Project # 1002068

Project Name: Town of Atrisco Grant Unit 6

DRB Comments

RE: Lots 150 & 151, Town of Atrisco Grant Unit 6

Sheet 2 of 2
 073135

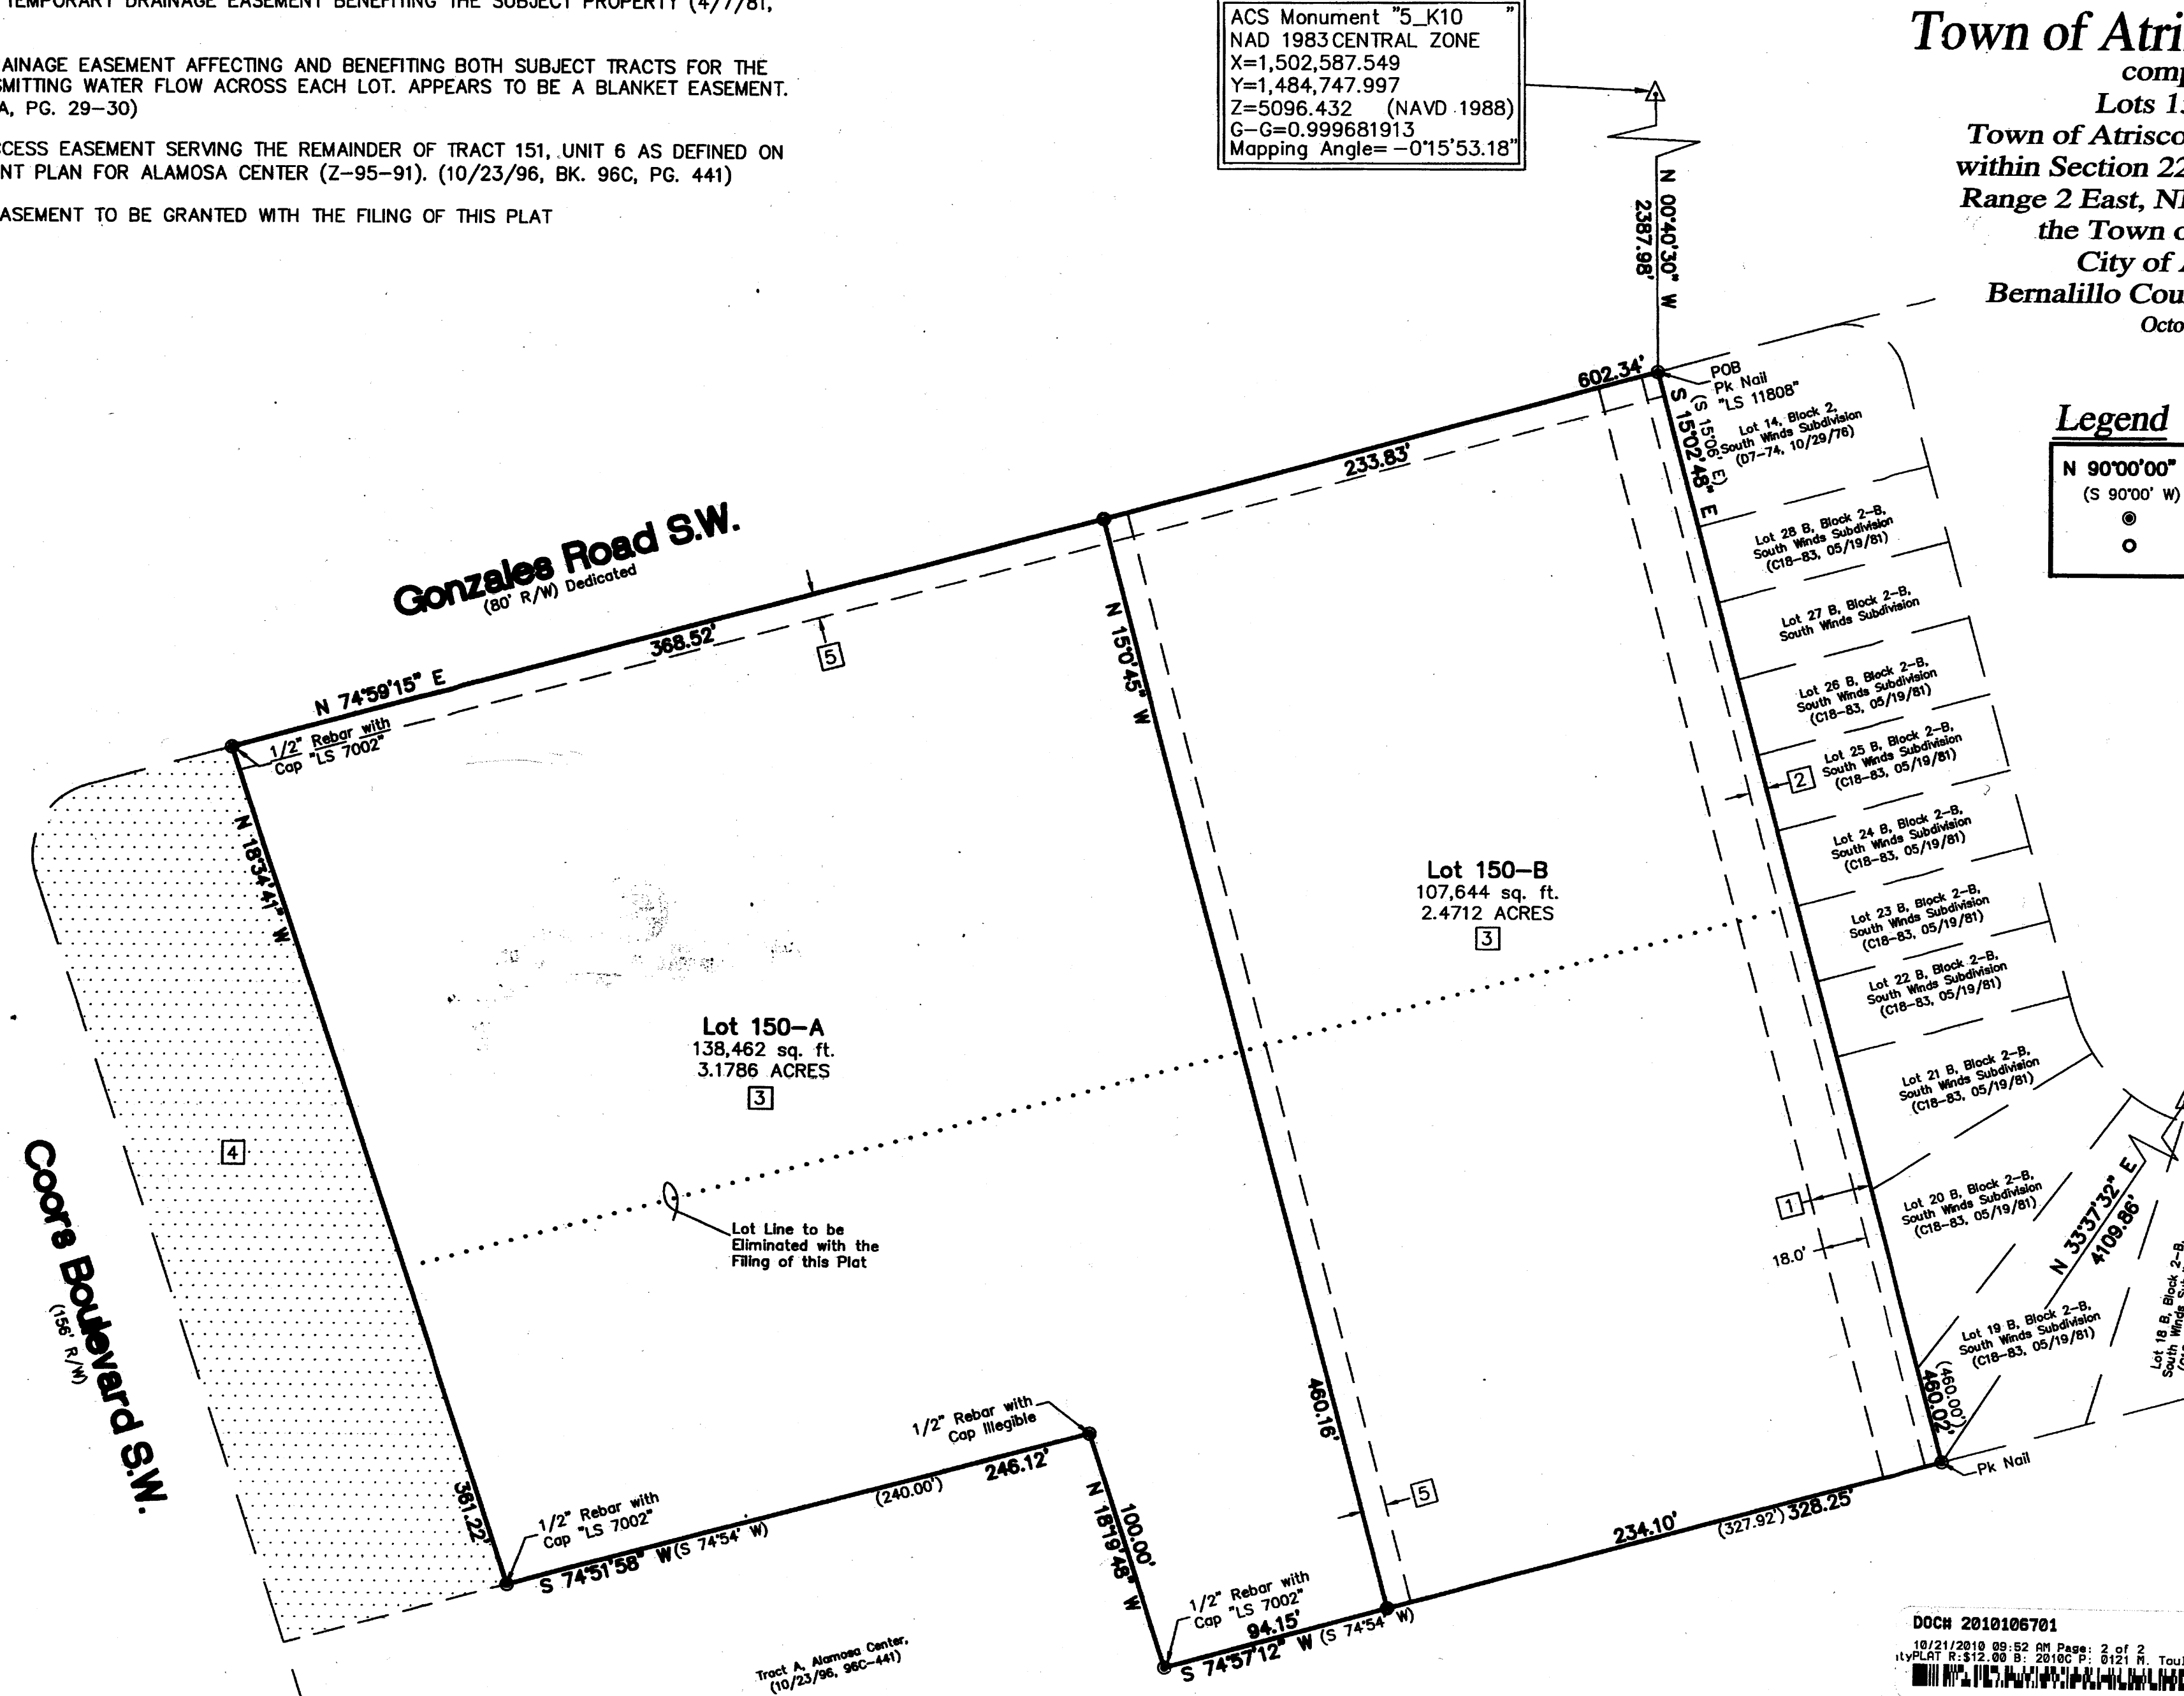
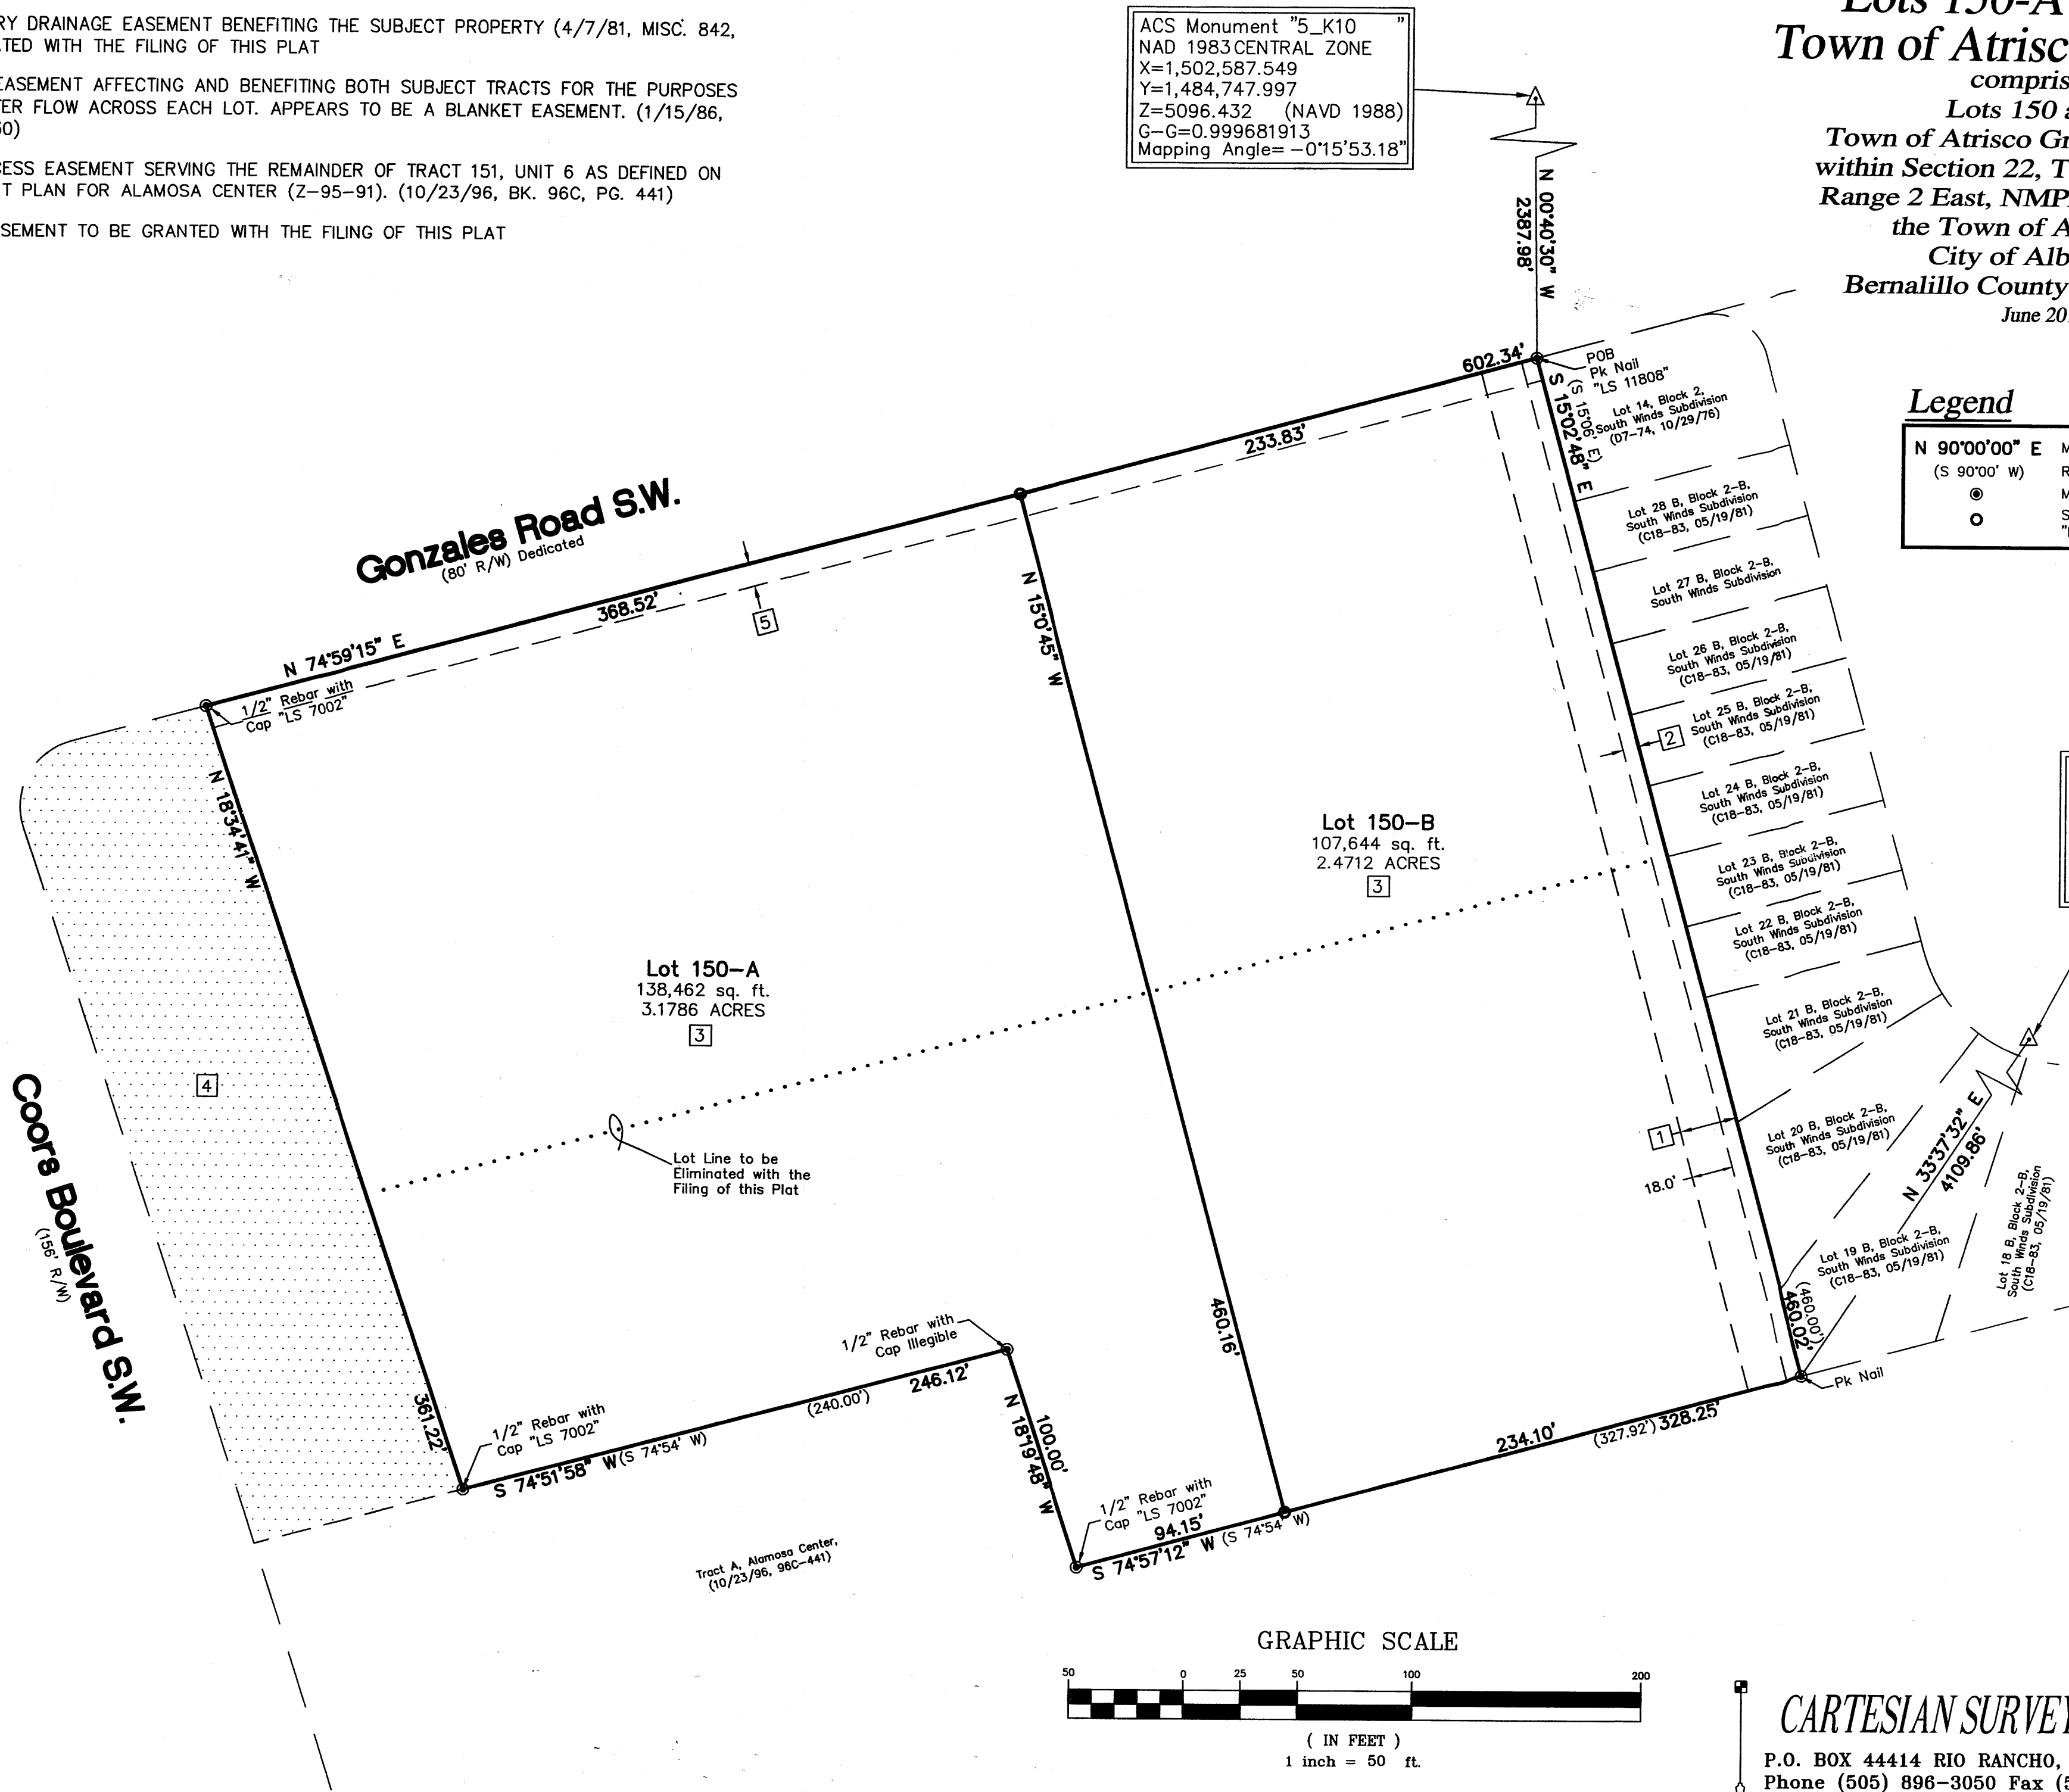
Beneficiaries of the easements proposed for Vacation must be “clearly and completely defined and all agree to the vacation” [§ 14-14-7-2(E)(1) of the Subdivision Ordinance], or else an advertised public hearing would be required.

Franchised utility companies need to sign-off on the plat or acknowledge their approval of the plat in writing. AGIS needs to approve the .dxf file prior to Planning sign-off.
